Attachment K – Detailed Response to Submissions Table

Attachment K – The Children’s Hospital at Westmead - Multi-storey Carpark (SSD-10434896) – Detailed Response to Submissions Table

THIS DRAWING HAS BEEN DOCUMENTED IN COLOUR.  
THIS DRAWING IS REQUIRED TO BE PRINTED IN COLOUR.  
FAILURE TO DO SO MAY RESULT IN LOSS OF INFORMATION.  
BLACK & WHITE PRINTING MAY BE USED IF SPECIFIC BLACK & WHITE  
DOCUMENTS HAVE BEEN OBTAINED FROM WIG.

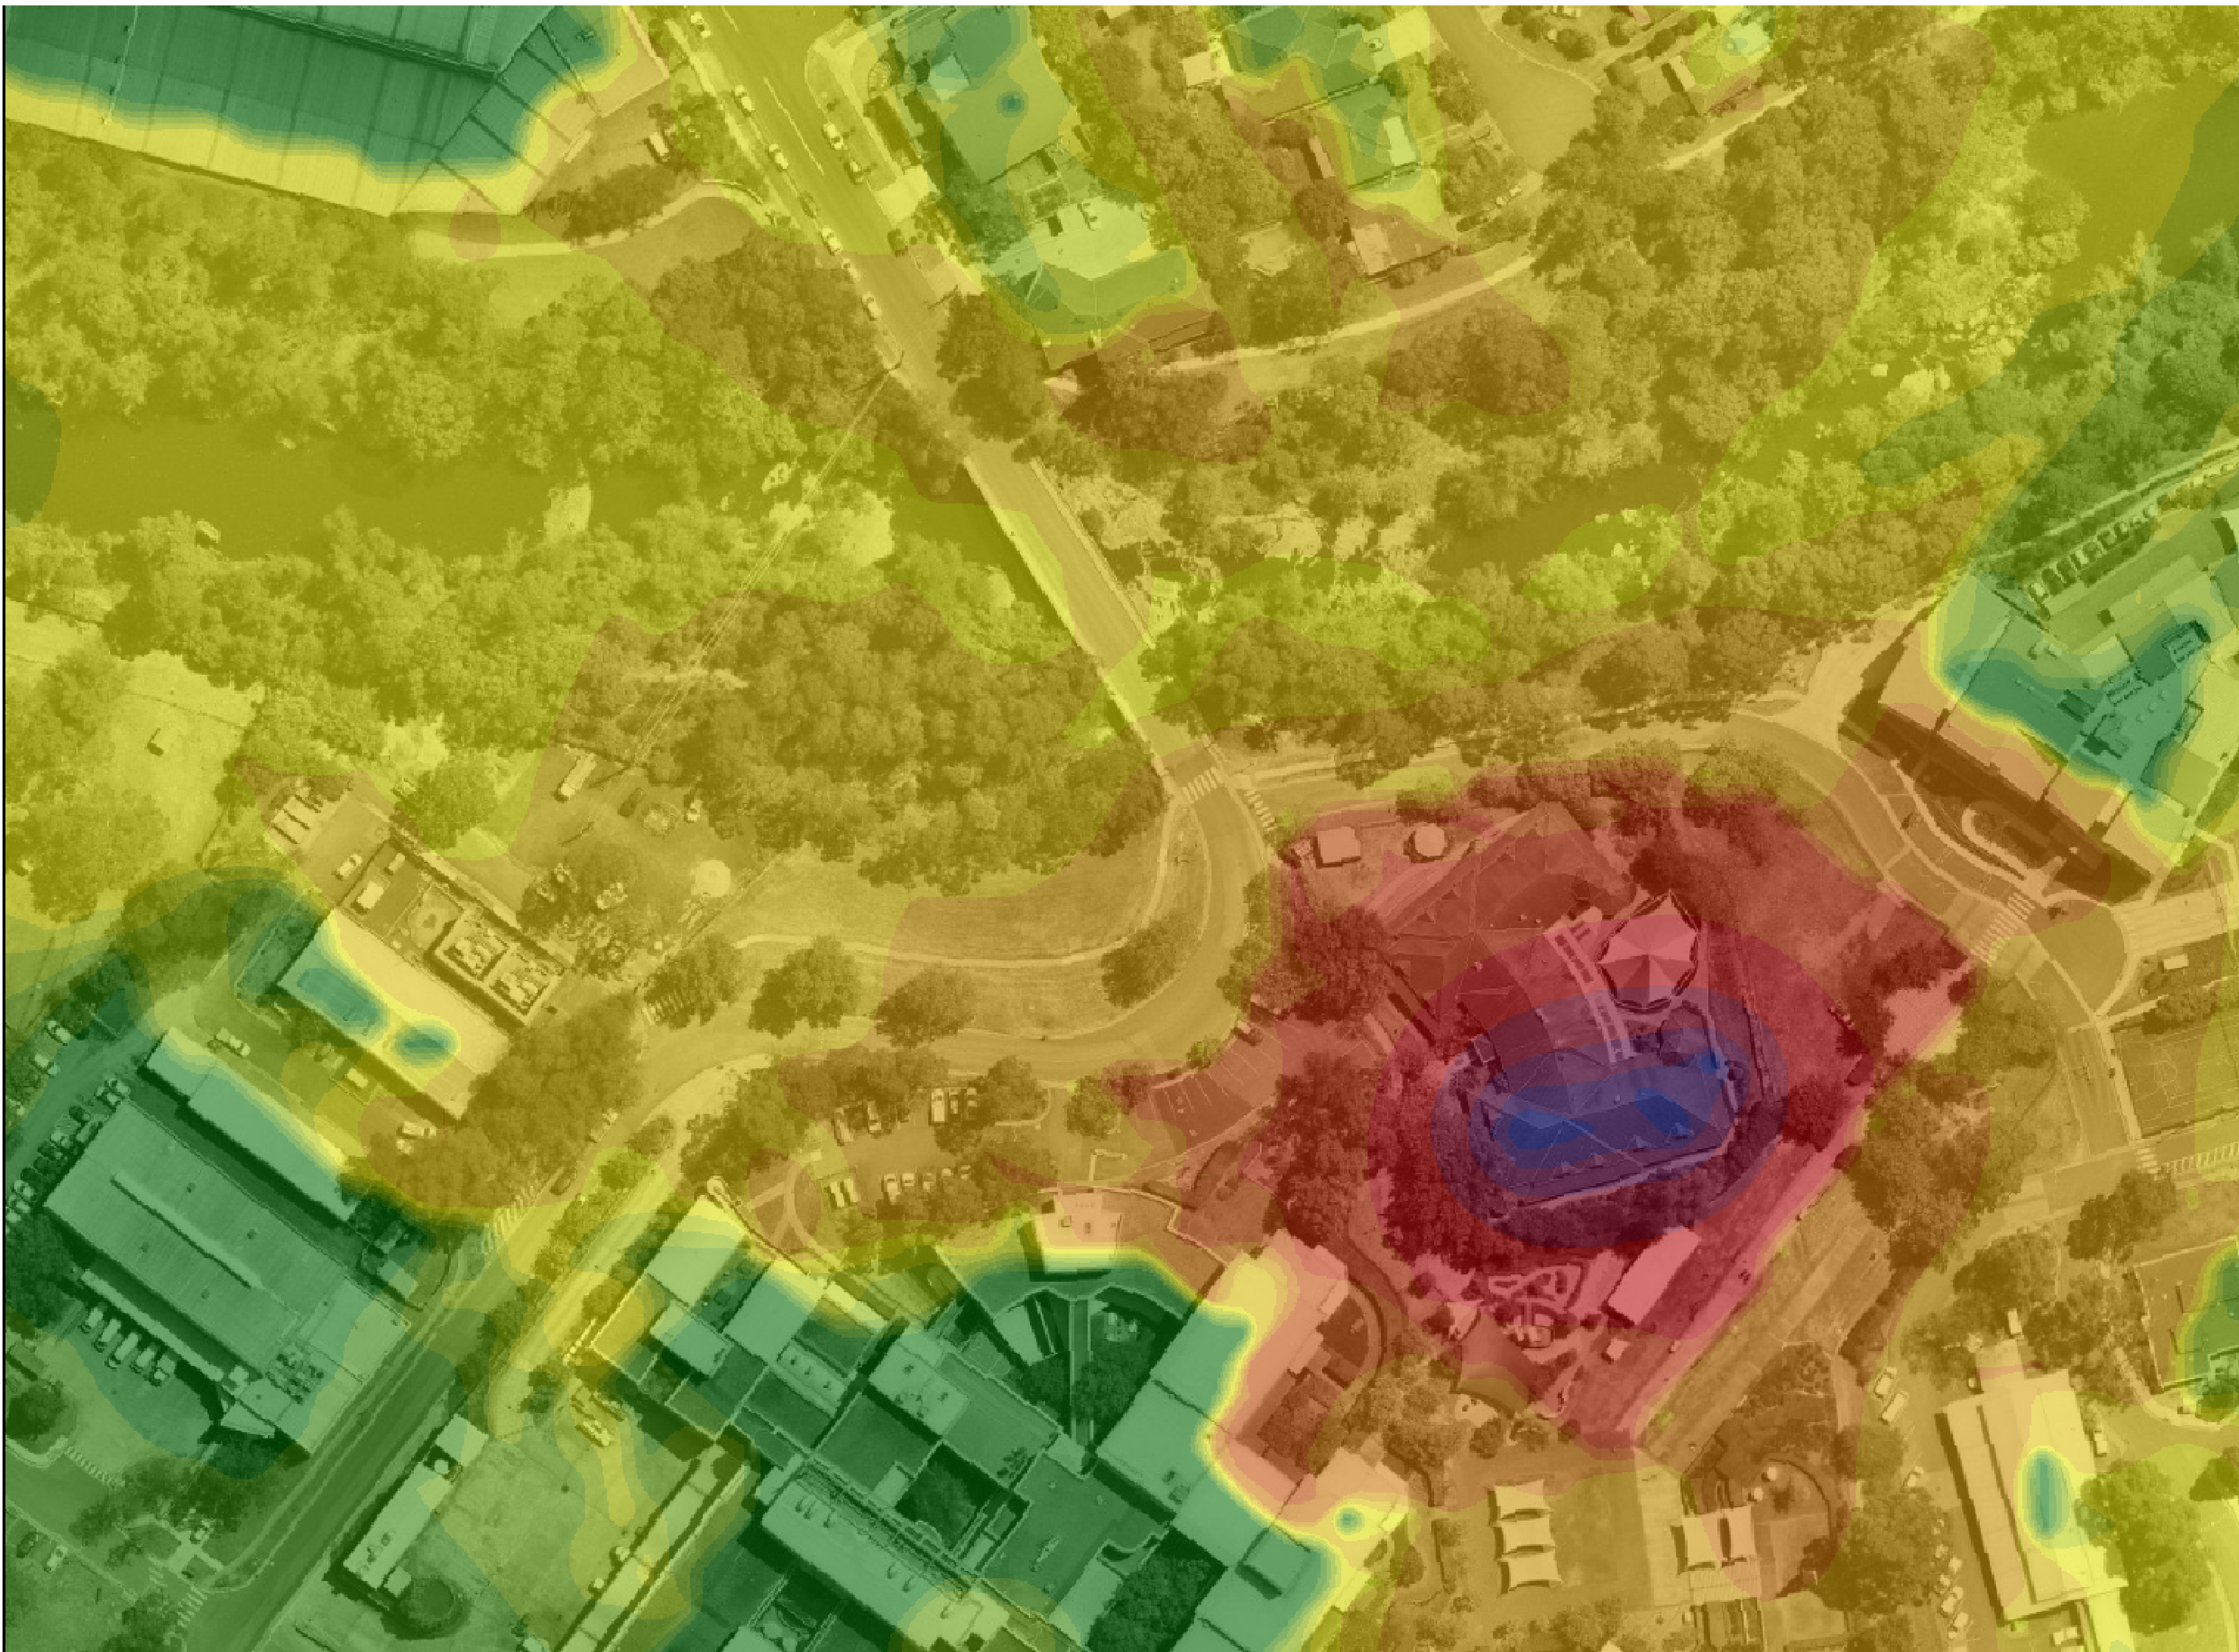
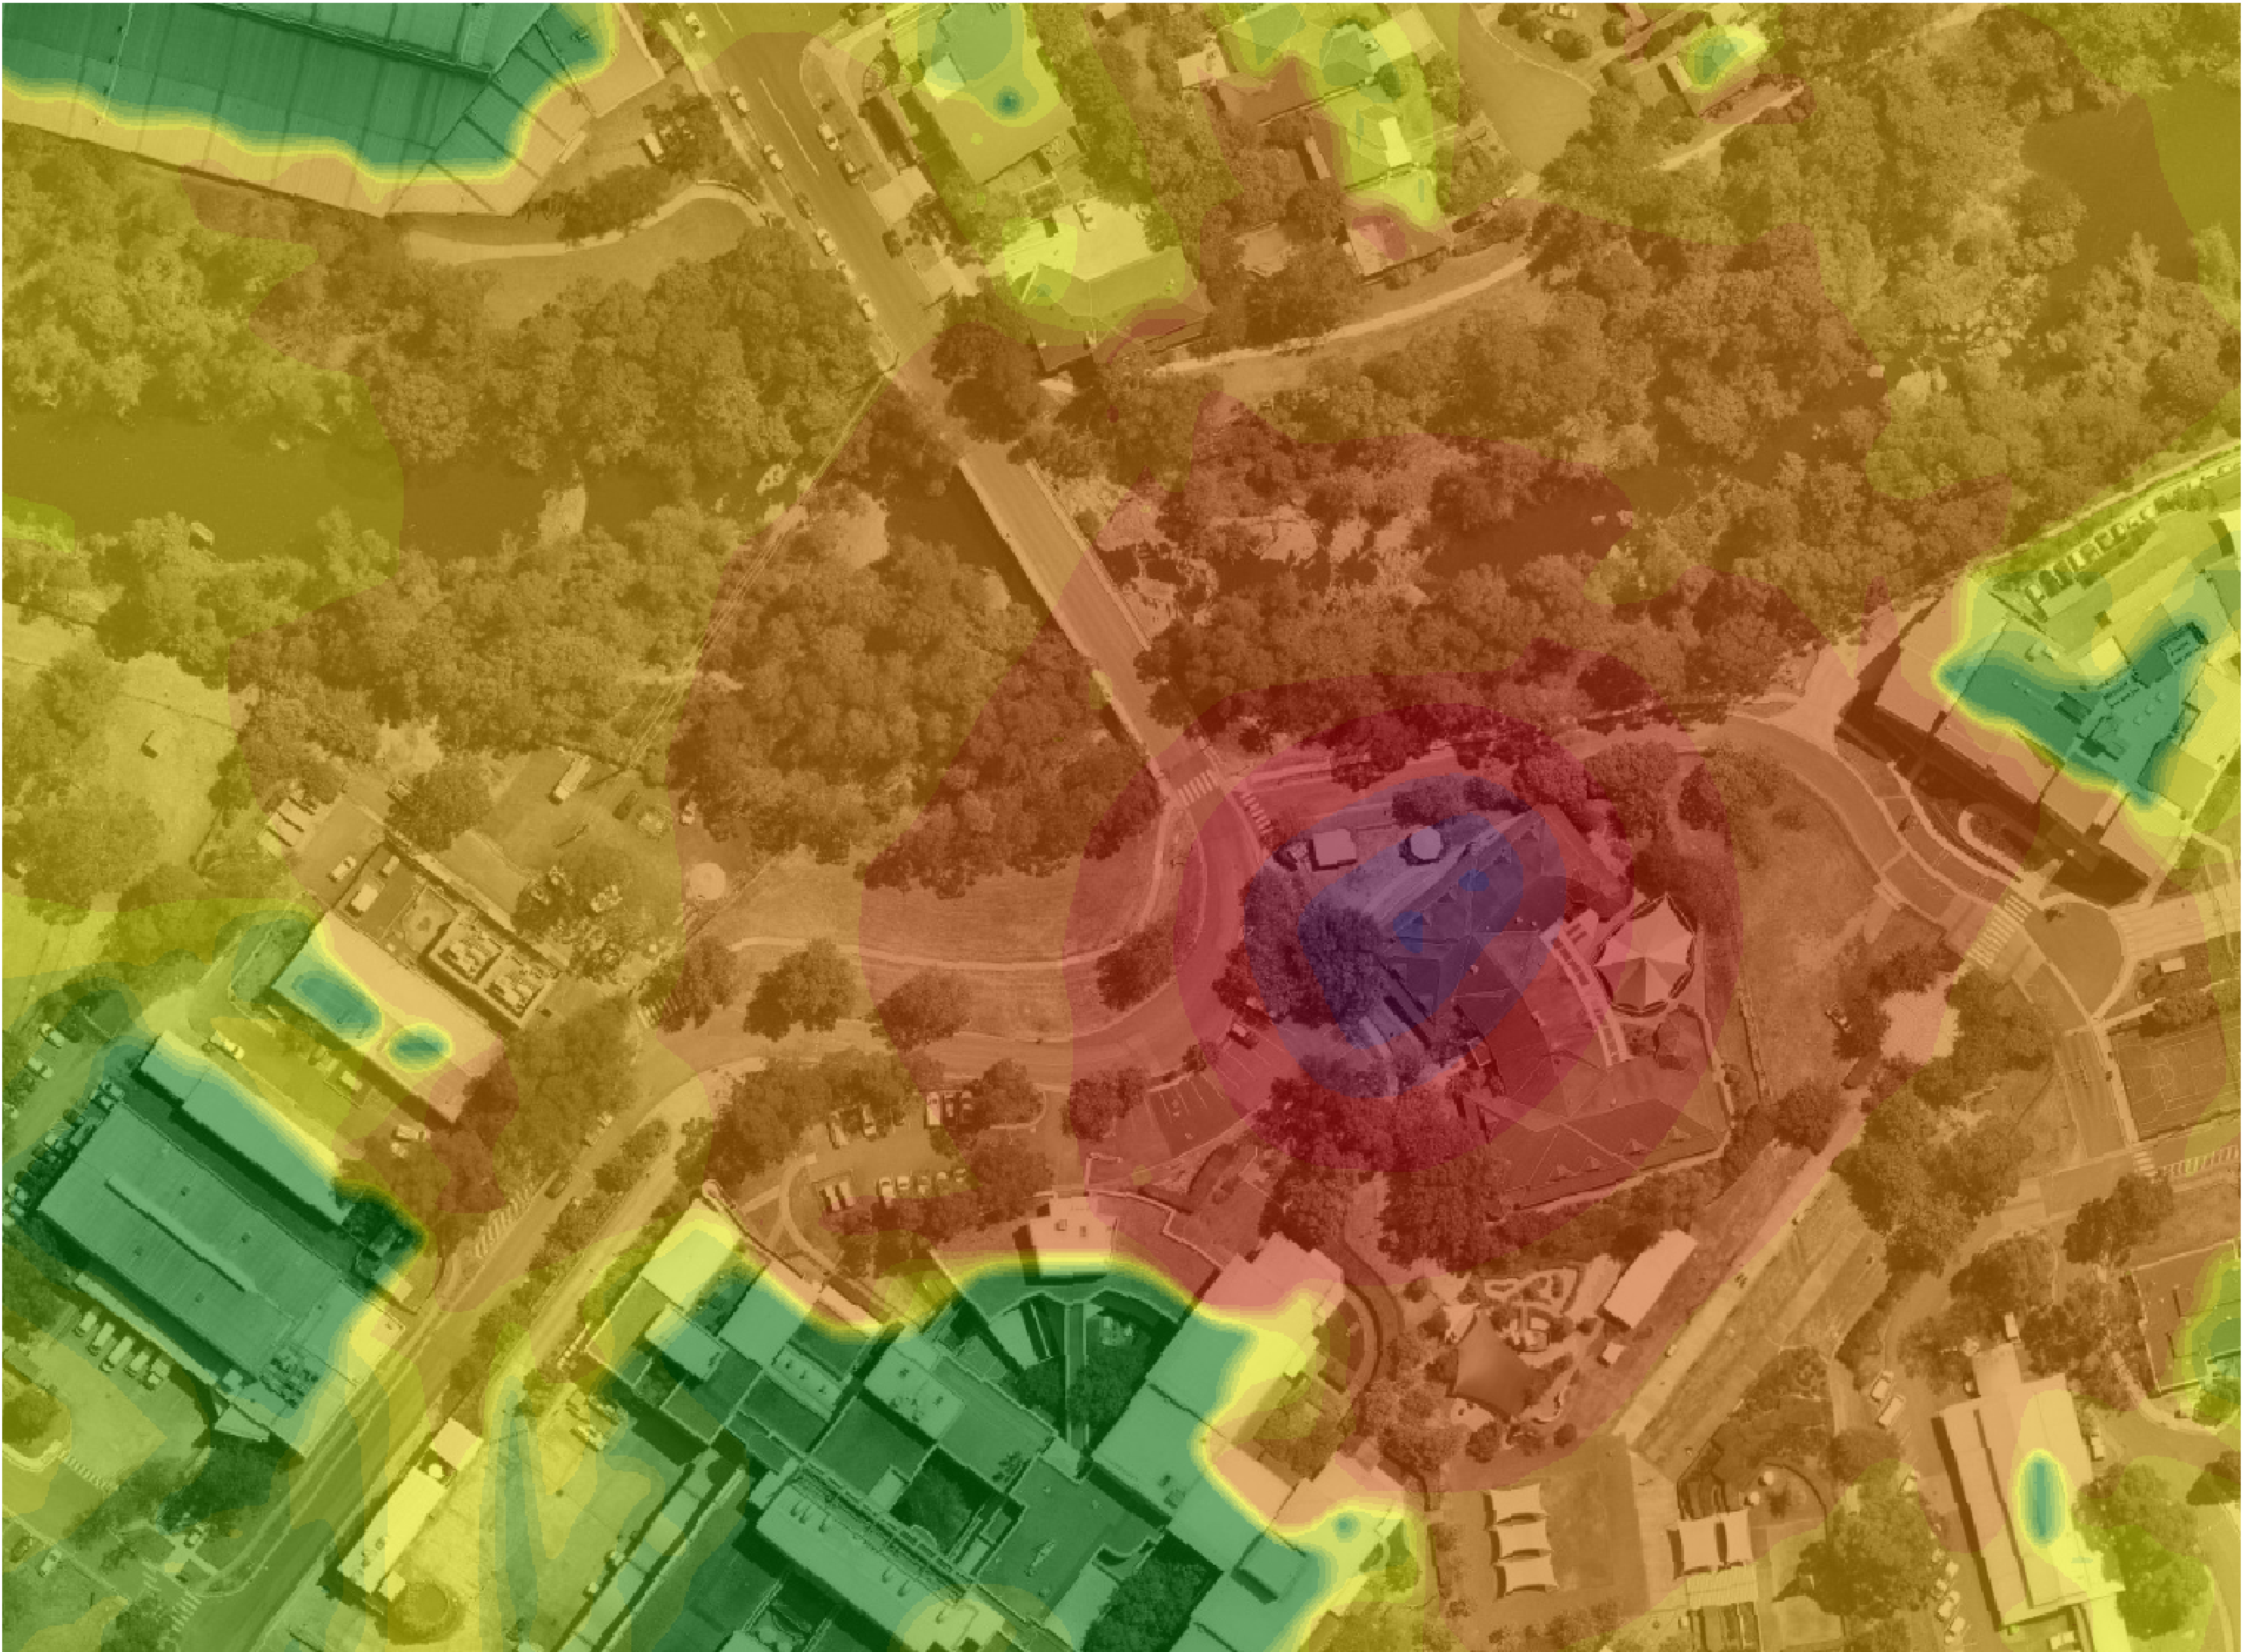
Row	Issue raised	Proponent’s response
Department of Planning, Industry and Environment		
1	<p>Acoustic Impacts</p> <p><i>Cumulative construction noise impacts associated with surrounding concurrent developments are to be provided (particularly the Paediatric Services Building Redevelopment).</i></p>	<p>The construction program indicates the following timing for construction:</p> <ul style="list-style-type: none"> • The MSCP construction will be occurring for the duration of the Paediatric Services Building (PSB) construction; • The structure and façade work for the MSCP are proposed to occur from July 2022 to March 2023; and • The PSB (subject of a separate planning approval) inground works will take place approximately from January 2022 to July 2022. The upper structure will commence from July 2022 to Feb 2024. The PSB construction, commissioning and handover is not until Q1 2025. <p>Given that the MSCP and PSB (subject of a separate planning approval) are 250m apart, and buildings that separate them provide acoustic shielding between the two sites, the cumulative noise impact during simultaneous construction is concluded as negligible. During a worst-case scenario without the implementation of mitigation measures, the PSB construction noise would be less than 30 dB(A) at the site of the MSCP, and would therefore, not contribute to the noise level at receivers adjacent to the MSCP.</p> <p>For further information refer to updated Acoustics Report, prepared by Stantec at Attachment H.</p>
